Charlotte Department of Transportation

Memorandum

Date: December 19, 2007

Subject: Rezoning Petition 08-033: Located on the west side of Park Road
between Heather Lane and Drexel Place

**ILLUSTRATIVE  
SITE PLAN**

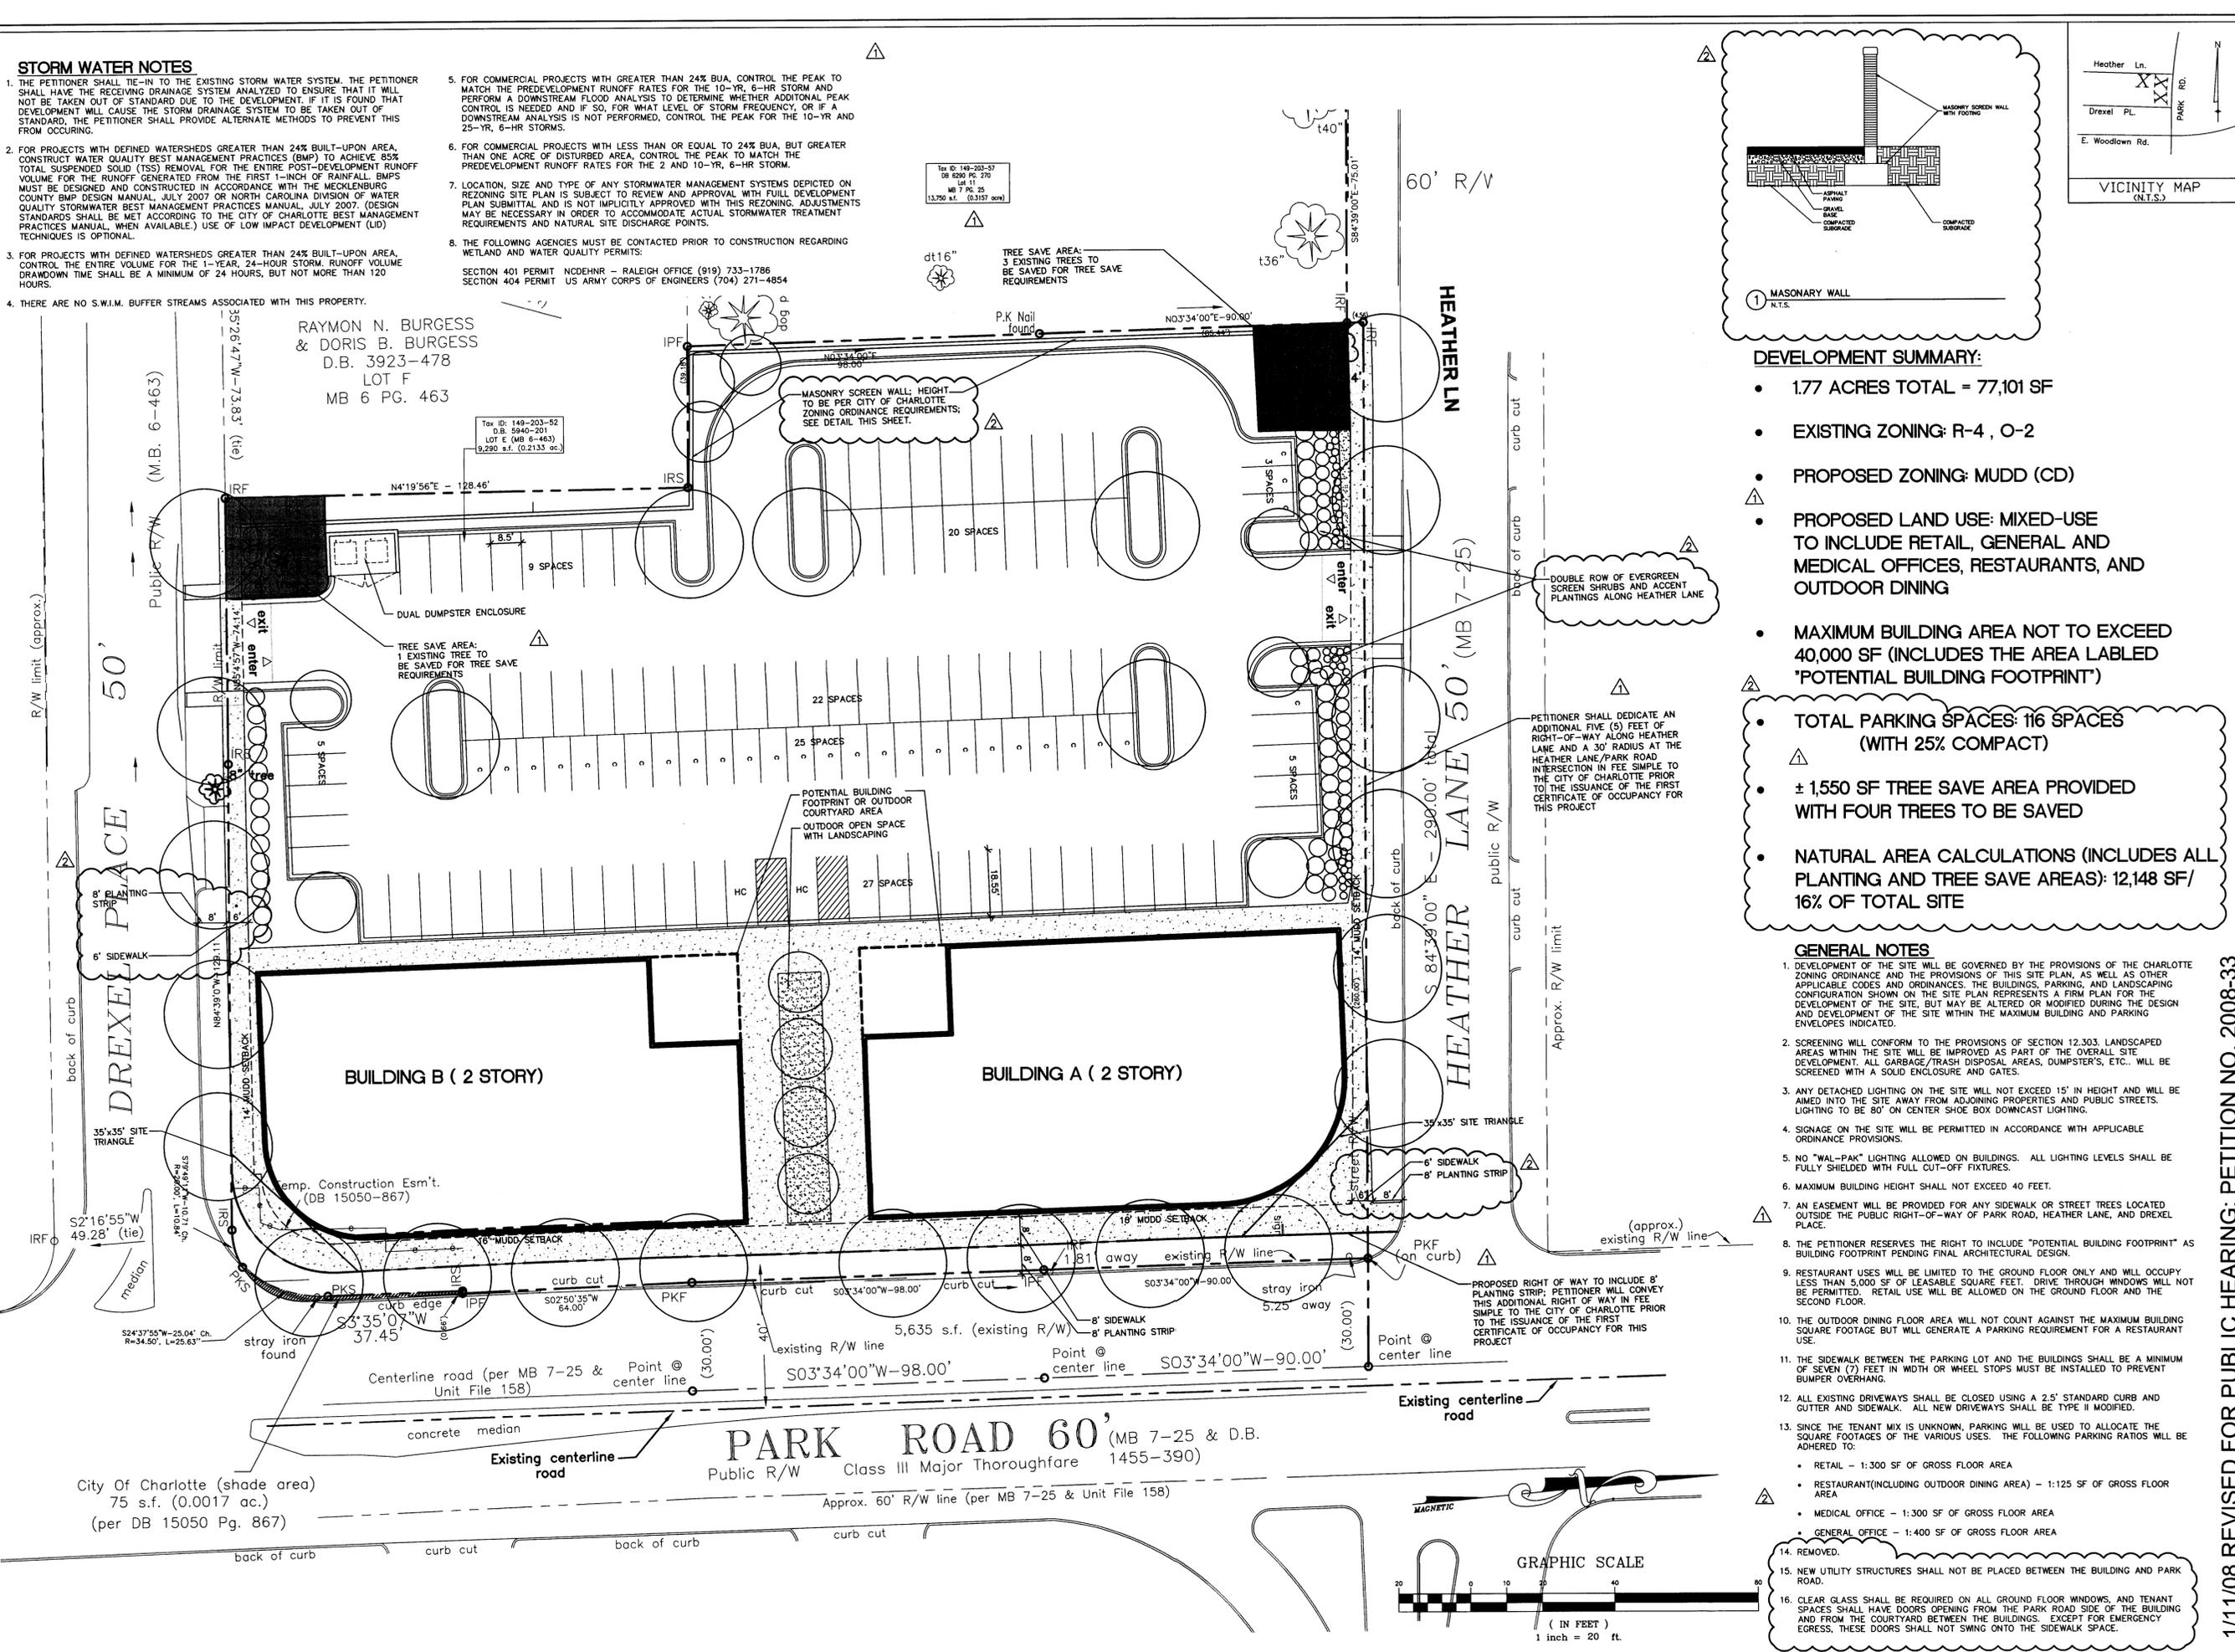
1. A flag note on the plan indicates a proposed right-of-way on Park Road and refers to Note 10. The General Notes only include 8 notes. We request that the proposed right-of-way line be revised to include the entire planting strip and that the petitioner convey this right-of-way in fee simple to the City.
2. The existing right-of-way along Heather Lane to the west of the site is 60 feet and along the site's frontage is 50 feet. We request that the petitioner dedicate and convey in fee simple an additional 5 feet of right-of-way on Heather Lane and a 30-foot radius at the Heather Lane/Park Road intersection. This will help to provide a consistent right-of-way width along Heather Lane.

3. All existing driveways need to be replaced with 2.5-foot standard curb and gutter and sidewalk. This needs to be noted on the conditional site plan.
4. The driveways to the site are required to be Type II-Modified (ramp type) that provide for the sidewalk grade to be maintained through the driveway.

To facilitate building permit/driveway permit review and approval, the site plan must be revised to include the following:

- Dimension width of the existing and proposed driveways.
- New/reconstructed driveways must be drop curb ramp Type II Modified driveways.
- Indicate the locations and widths of all adjacent and opposing driveways.
